Comment from Greenspace

NOTIFICATION FROM ARUN DISTRICT COUNCIL
Town & Country Planning Act 1990 (as amended)
Town and Country Planning (Development Management Procedure)
(England) Order 2015
Planning Permission
APPLICATION LU/117/17/PL

Site Address: Formerly 'The Tap and Barrel' 2 - 13 Duke Street
Littlehampton BN17 6EU

Description of Works: Demolition of existing building, and erection of a new building to provide 10No. new flats, comprising 9No. two bedroom flats and 1No. one bedroom flat.

Fig 3. Proposed ground floor site layout

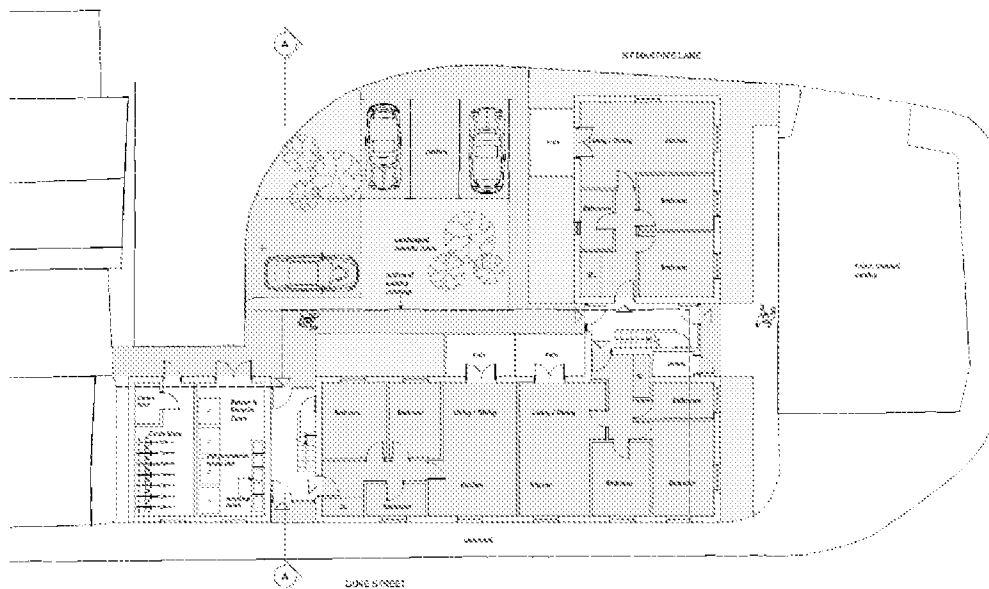
The proposed dwg 332-P-04 indicates 10no dwellings into this site and the layout also indicates a small section of landscaped amenity space, which is good to see as greening to soften any area, when maintained is generally seen as a beneficial on any development. The drawing is an indicative drawing only and needs to include in plan form species choice, plant numbers, densities and size at time of planting being proposed for this area. The detail submitted at present is considered to be insufficient in detail for a considered opinion to be made.

I recommend that the above detail is submitted for approval or conditioned as part of any decision.
